Subject: RE: Planning Consultation on: Y/50/20/DOC

Engineers Comments Regarding Surface Water Drainage

Application No: Y/50/20/DOC
Registered: 10th June 2020
Site Address: Rookery Cottage Hoe Lane Flansham PO22 8NT
Description of Works: Approval of details reserved by condition imposed under ref Y/72/19/HH relating to Condition No 3 - surface water drainage.

Drawing Status	FOR APPROVAL
Client	Lara Mackendrick
Project	Rookery Cottage, Hoe Lane Flansham, Bognor Regis PO22 8NT
Drawing Title	Engineering Layout - Drainage & Level Design
Scale	VARIES
Date	May '20
Drawn By	DJL
Checked By	LDL
Drawing No.	D1828-002
Rev.	-

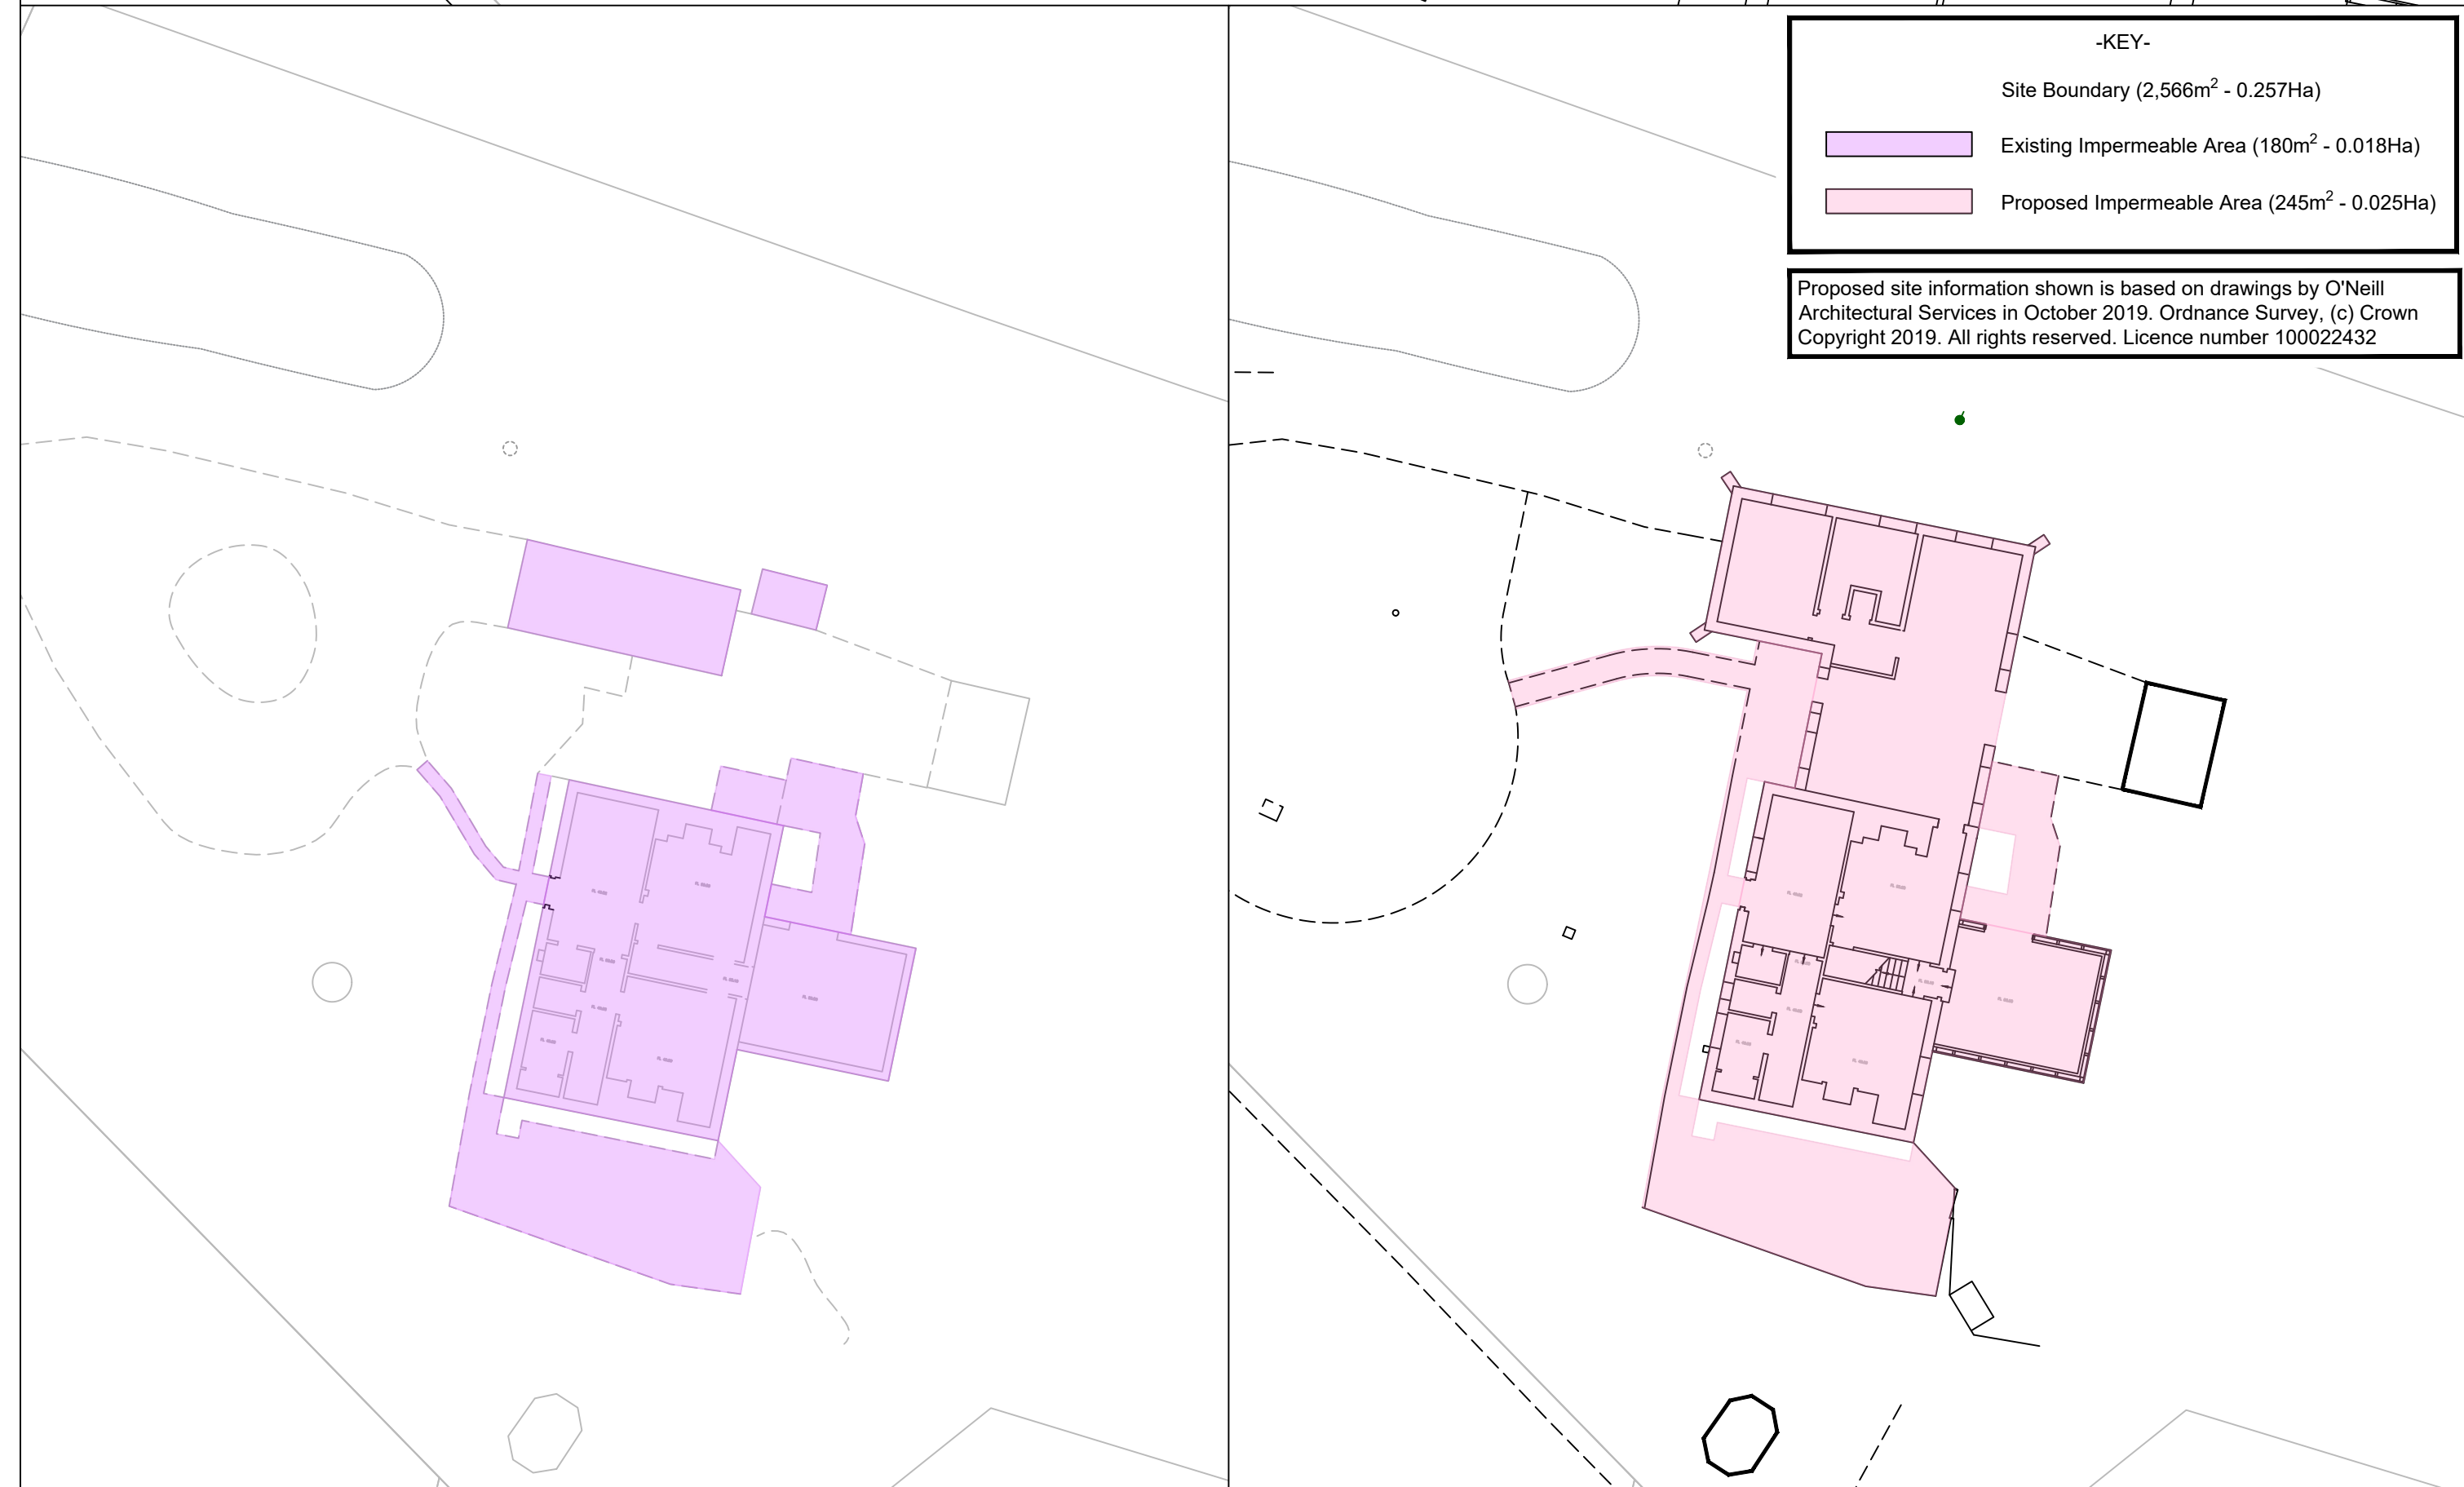
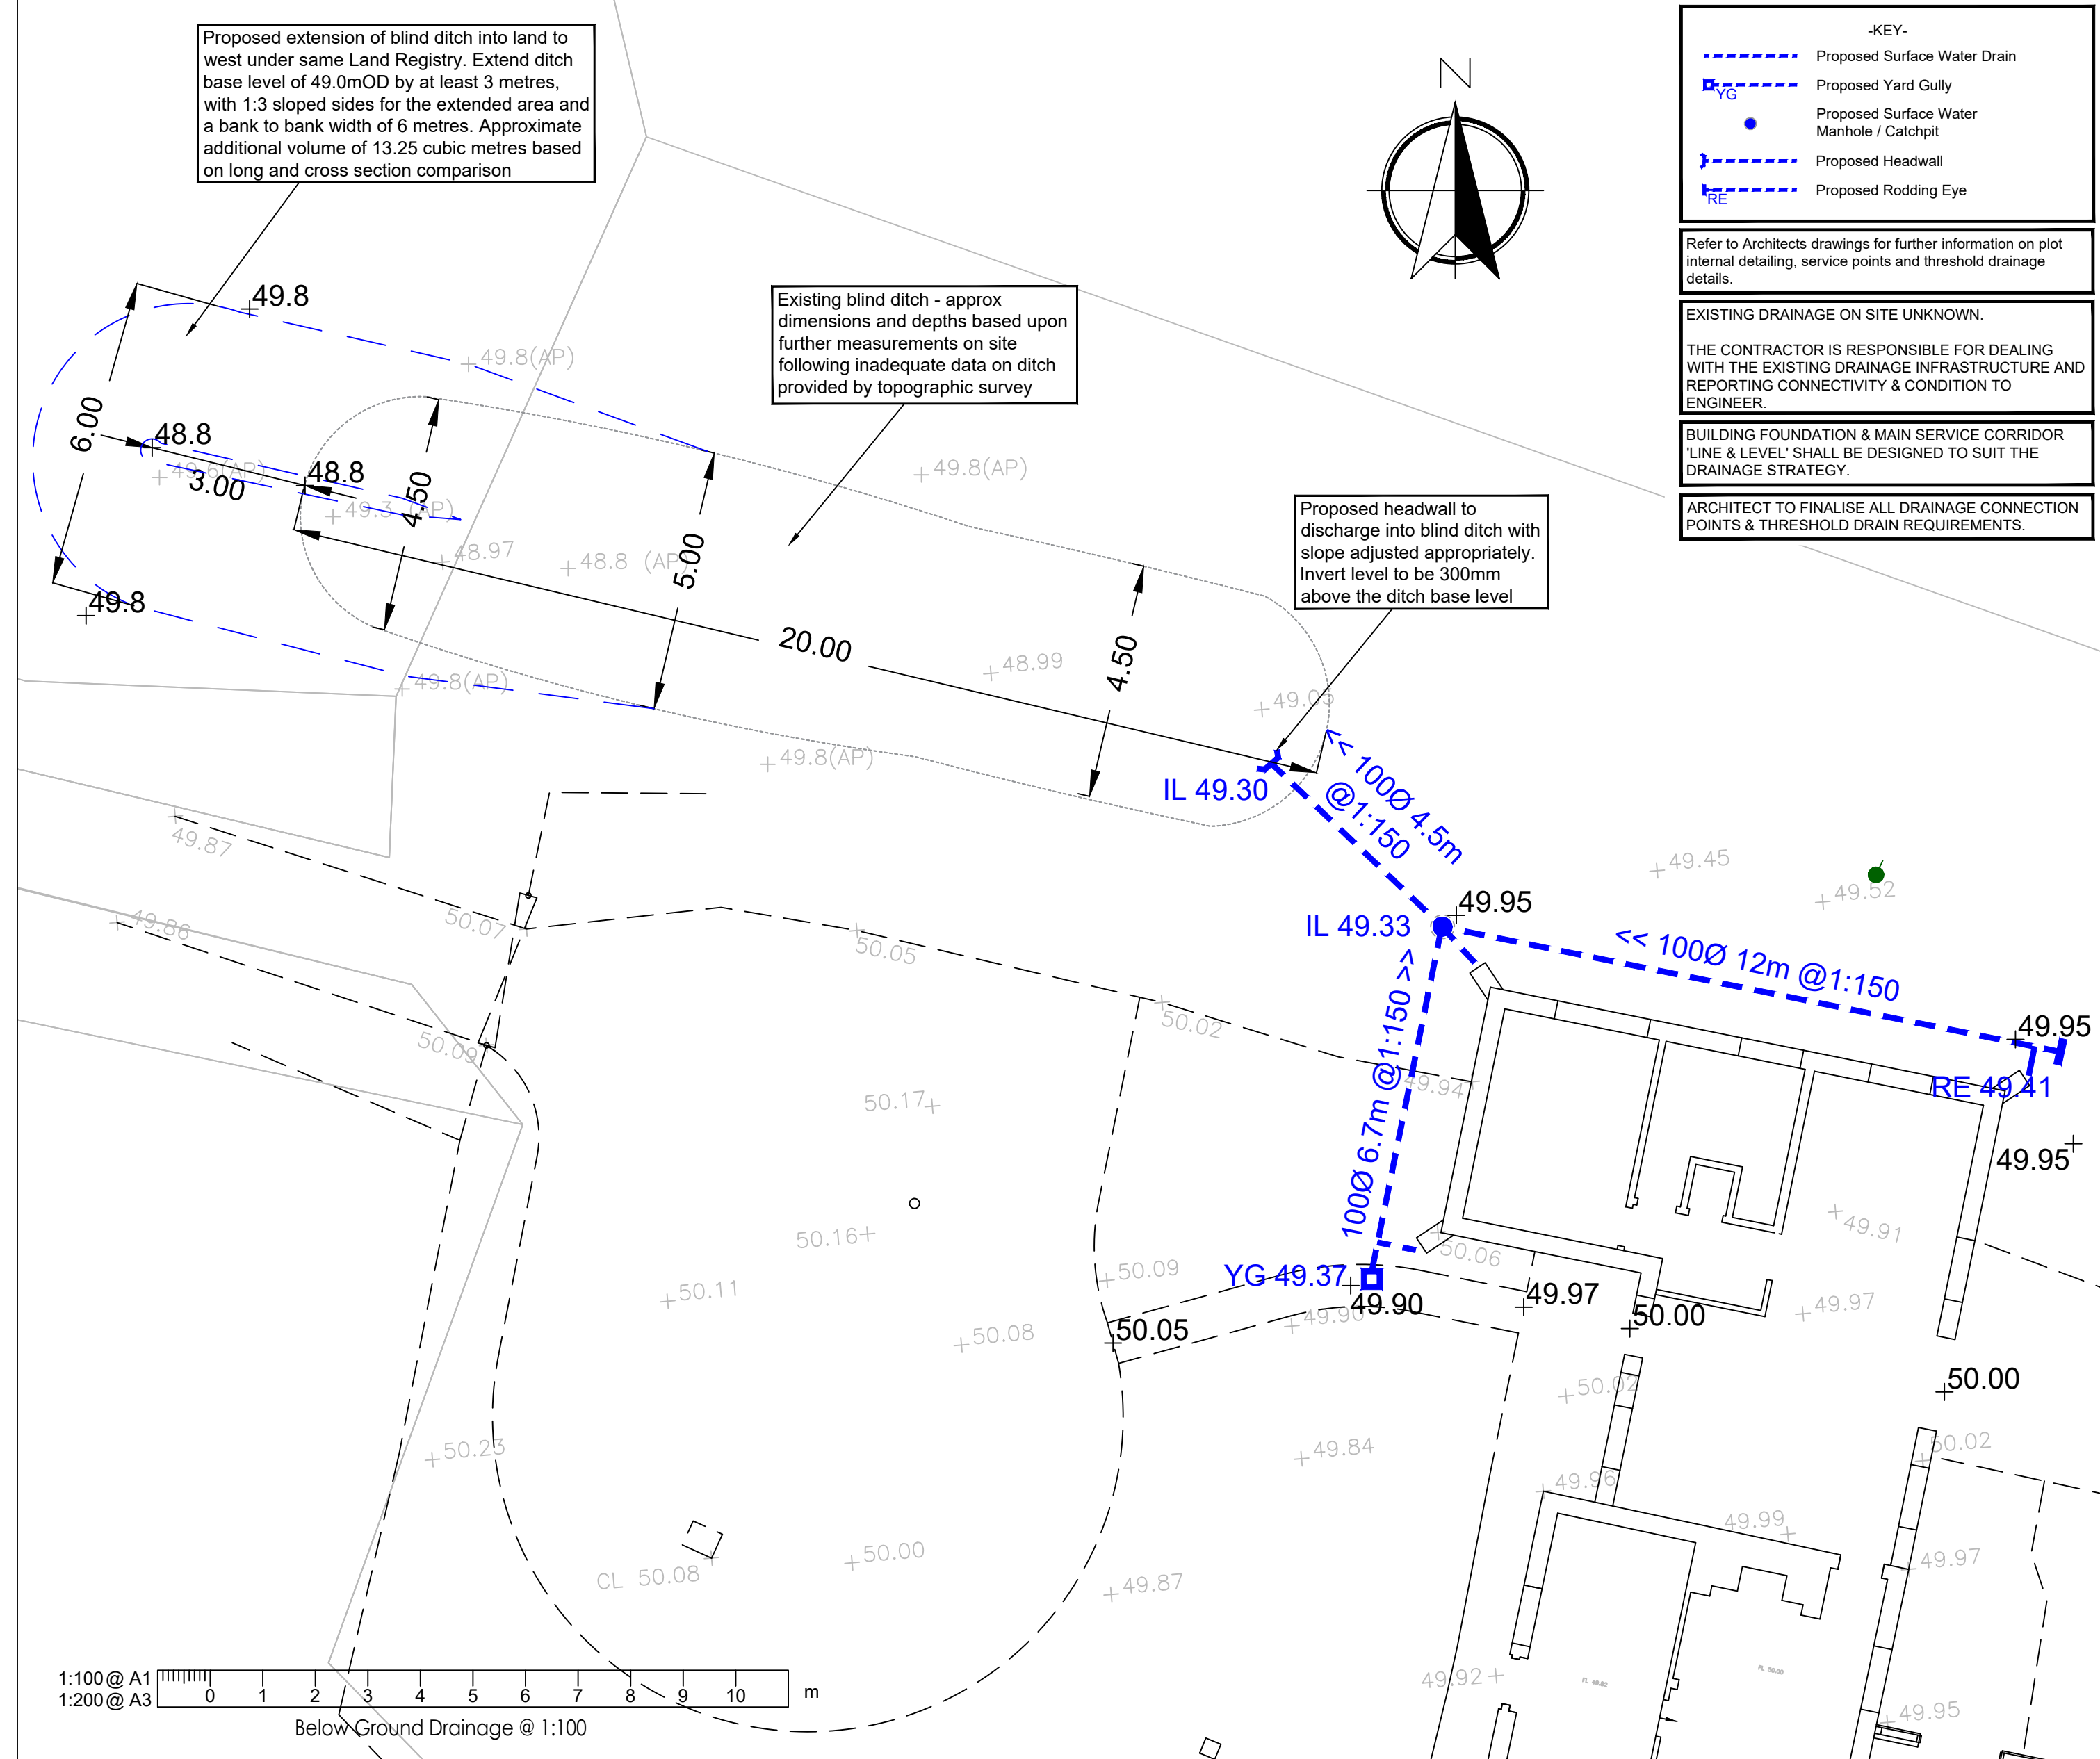
Please amend the inspection chamber to a catch pit (provide a sump). Once this is done I will be happy to recommend discharge of condition 3.
